Recommendation Report for Planning Permission for Works or Extension to a Dwelling

REF NO: EG/74/12/

LOCATION: 20 Highview Road
Eastergate
Chichester

PROPOSAL: Addition of two rooms over previous ground floor garage extension -
Resubmission of EG/60/12

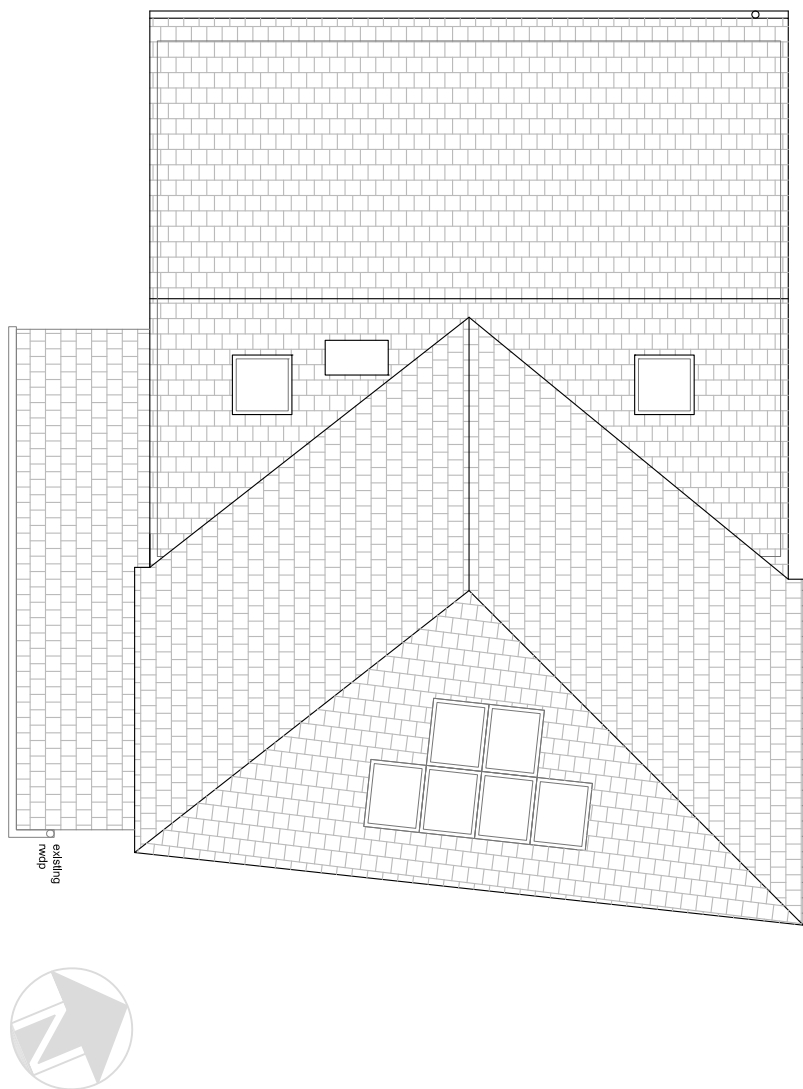
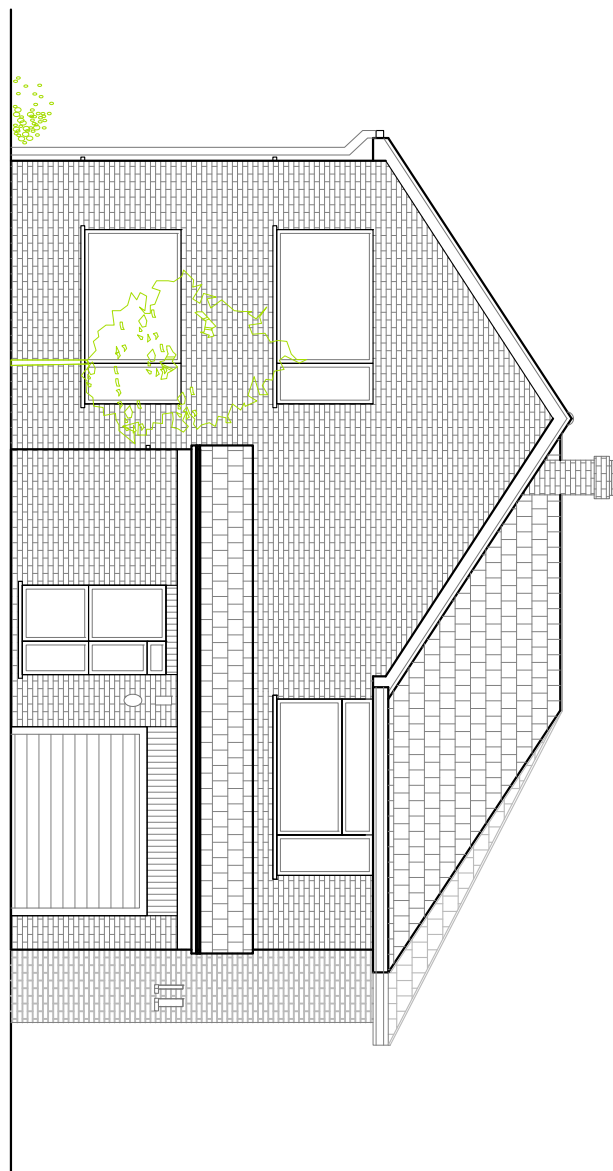
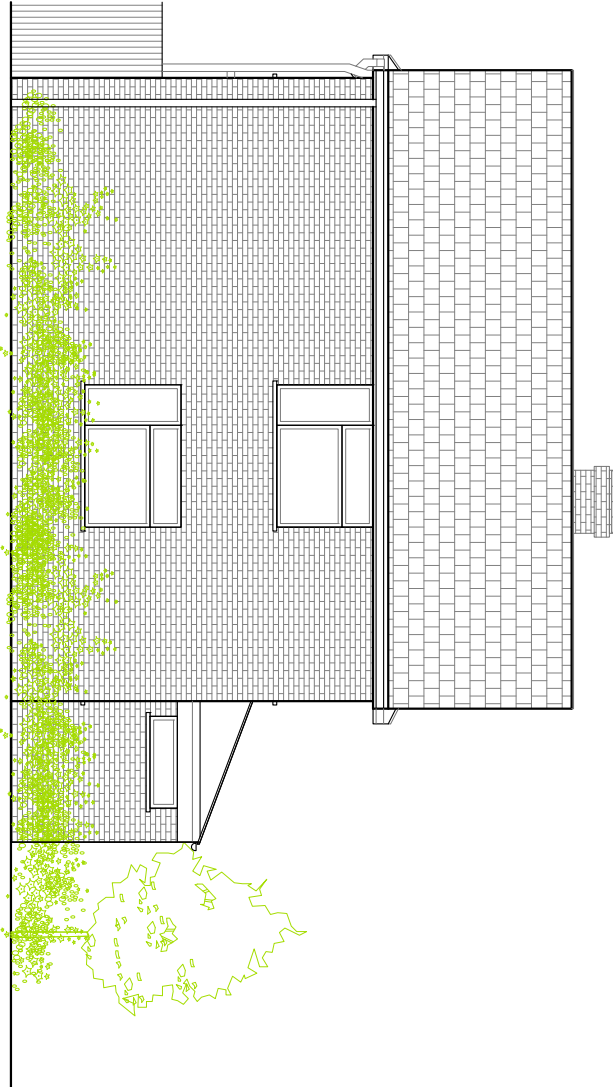
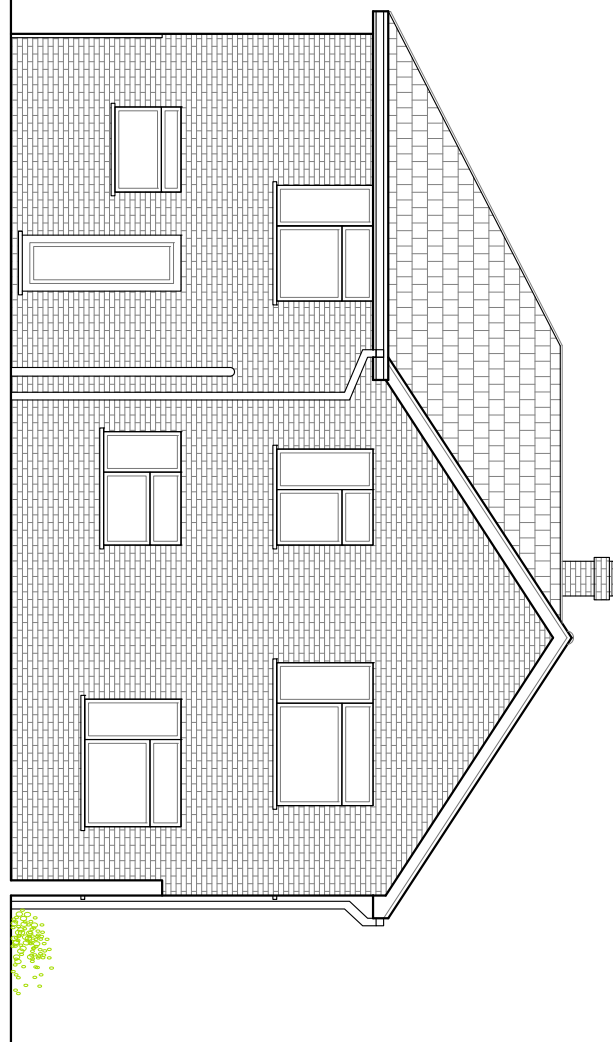
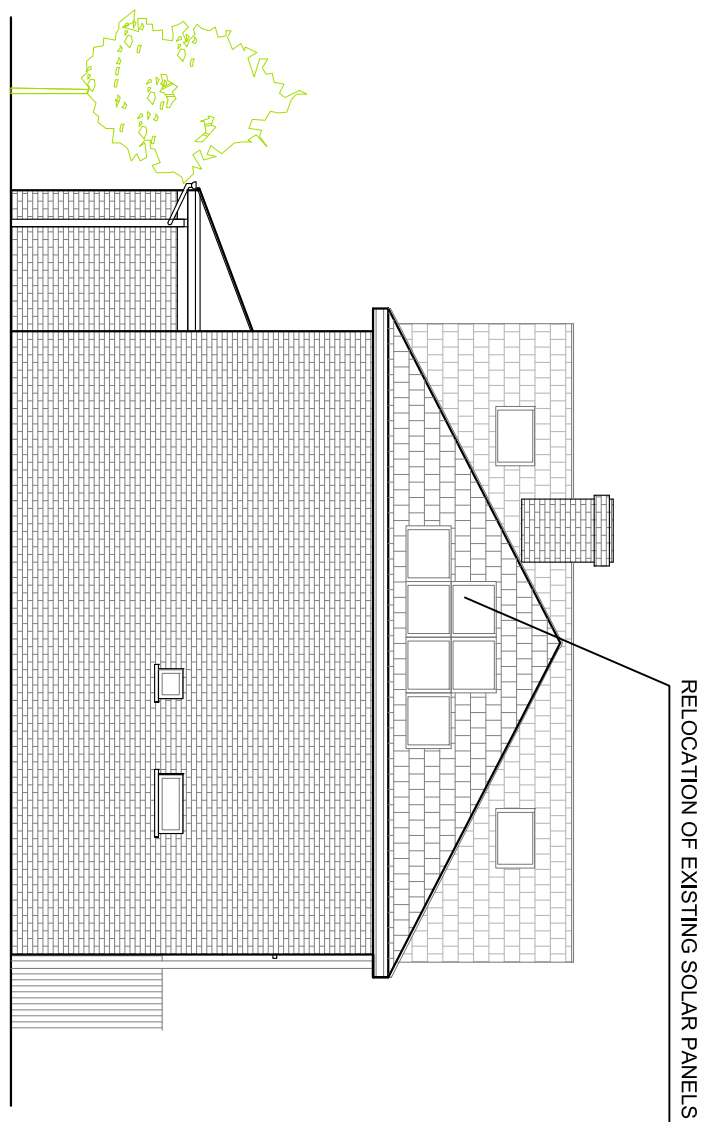
The application is a re-submission of application EG/60/12/ which refused consent for a first floor side extension. The application was refused by reason of its flat roof design that failed to integrate visually with the pitch, gabled roofline of the host dwelling.

The design of the extension is amended to incorporate a pitch, hipped roof. The width and depth of the proposed extension is identical to the previous scheme EG/72/12/. The ridgeline of the extension will be positioned 150mm below the roofline of the dwelling and the roof will be finished in matching tiles with facing brickwork on the external elevations of the extension. The current proposal is considered to be a more acceptable design that integrates visually to the host property, to comply with policy DEV19. The pitch roofline would be in keeping with the character and design of the property and would preserve the character of the streetscene.

The impact and relationship to the neighbouring property to the east at no. 18 was previously judged to be acceptable with no loss of privacy, daylight or outlook. There has been no material change to the site or the relationship to the neighbour. The addition of a pitch roof would have no adverse impact on the amenities of the neighbour.

- 3 No windows (other than those shown on the plans hereby approved) shall be constructed in the east elevation of the extension hereby permitted which adjoins the side boundary with no. 18 Highview Road without the prior permission of the Local Planning Authority on an application in that behalf.
